**Consultation Response from KC,
Lead Local Flood Authority**

2021/93567 Land off, Westgate, Cleckheaton, BD19 5DR

Erection of 194 dwellings with associated works

Date Responded: 9th March 2022

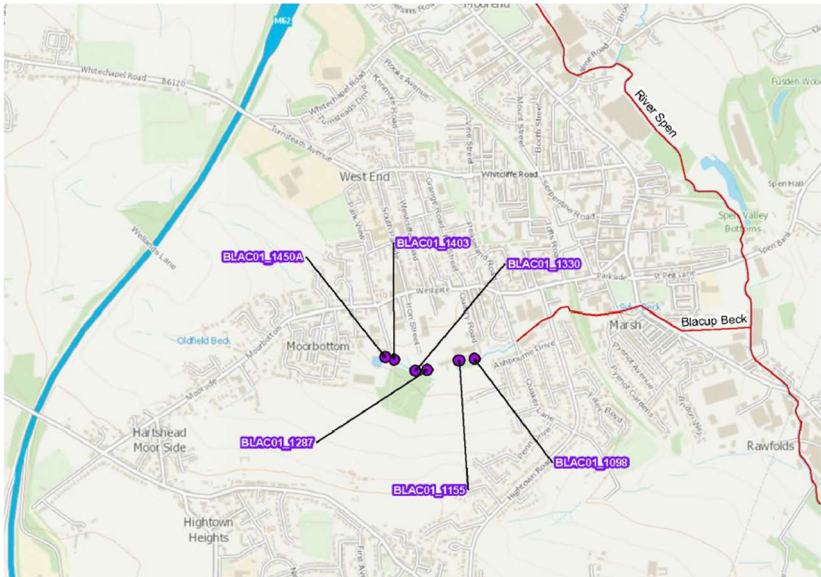
In addition to our comments of 28th November 2011, we note that a revised plan showing 1 in 100 year + 20% climate change indicates several plots to be within flood zone three (High Risk).

In accordance with local and national planning guidance, if this site is allocated it need not perform a sequential test, but the planning officer must consider the sequential approach to allocated sites that avoids putting property in higher risk flood zones and does not seek mitigation, which represents a reduction in risk but doesn't avoid it.
